Bramford – Twinstead:

Deadline 8 Response:

Braintree District Council (20041141) &

Essex County Council (20041299)

Figure 1
Noise Sensitive Receptors (including 55dB)

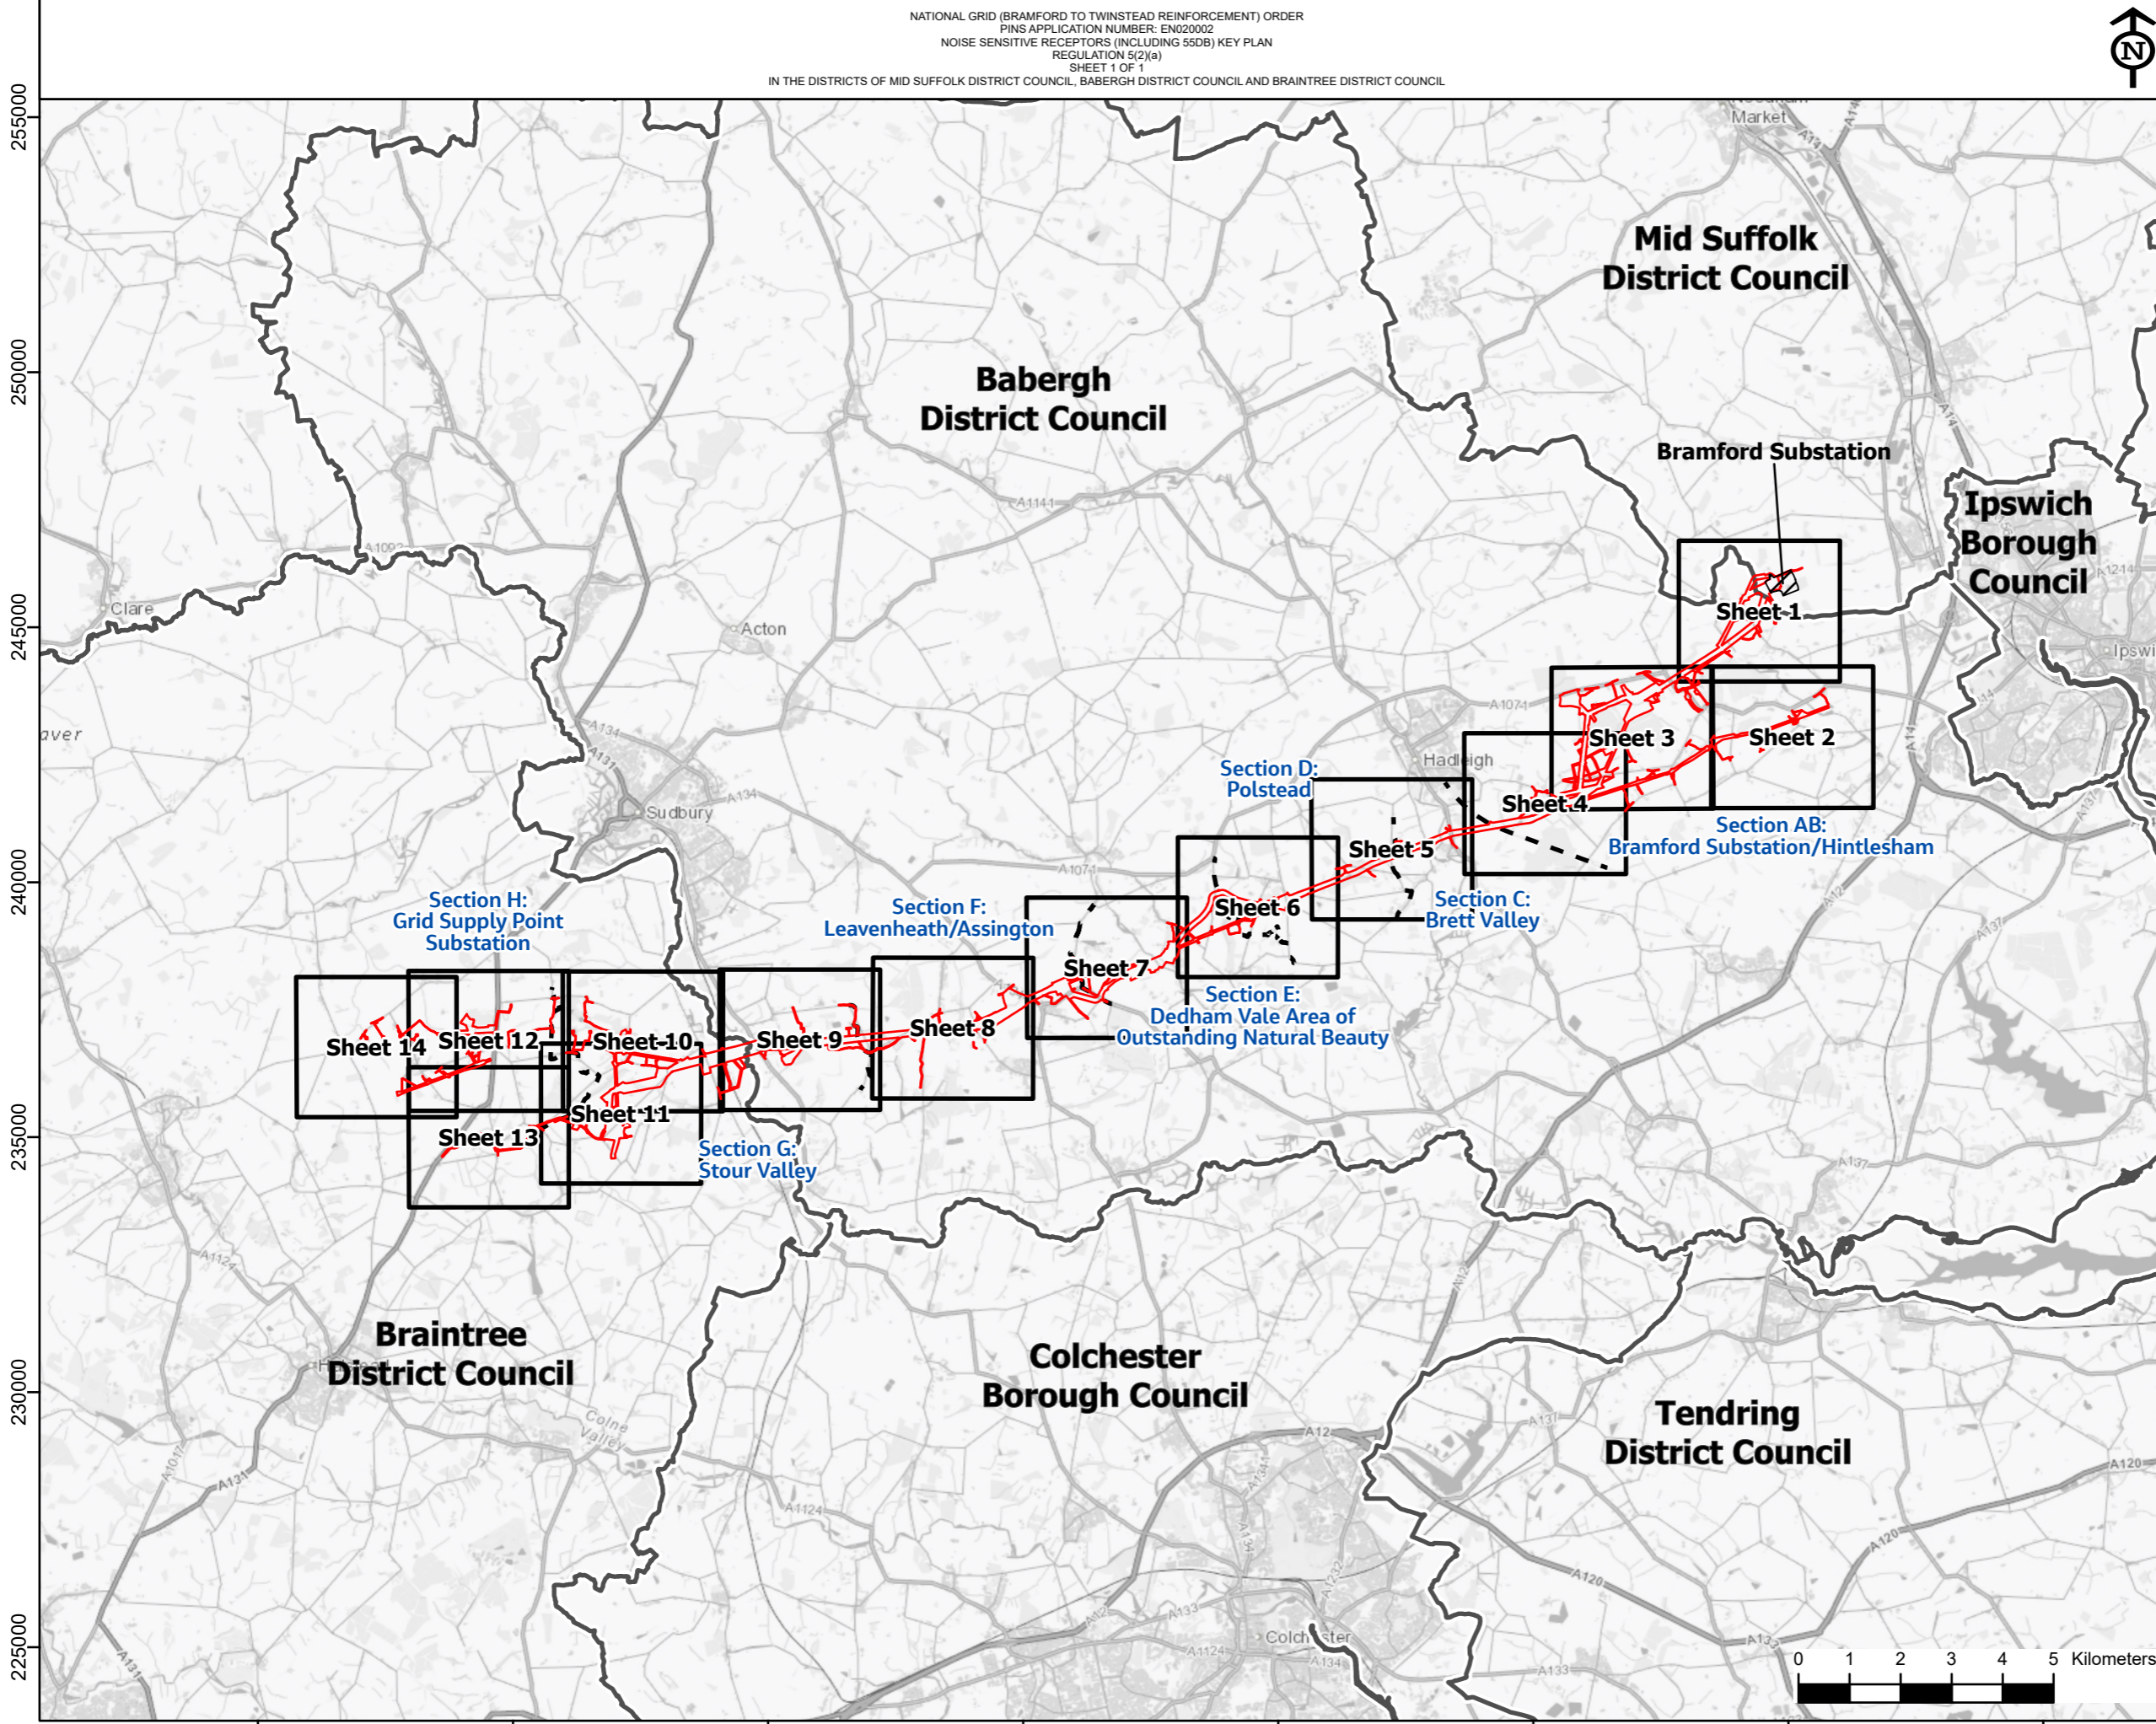
- 6.5.1 In NV2.11.24, The Councils deferred comments on the map/table presented by the Applicant, in regard to whether any additional properties should be included on the list.

- 6.5.2 It is noted that the Applicant has looked across the extent of the order limits and removed receptors which are outside of the temporal limits i.e. activity does not exceed 10 or more days of working in any 15 consecutive days or for a total number of days exceeding 40 in any 6 consecutive months. Having carried out a review of receptors based on the plant lists and distances at which SOAEL (Significant Observed Adverse Effect Level) is exceeded within Appendix 14.1, as well as receptor locations in Figure 14.1, plus reviewing the order limits plus the distances within which SOAEL that may be exceeded, The Councils do not consider that any further receptors need to be included within the table/map presented by the Applicant.

- 6.5.3 However, based on the absolute levels where mitigation is applied, short term impacts maybe occurring at sensitive receptors. The Councils recommend that those receptors which do not exceed the temporal threshold but do exceed the Category A threshold limits in accordance with BS 5228-1, should be notified of any potentially disruptive works in advance of commencing the work. The CEMP should therefore be adjusted to take this into account.
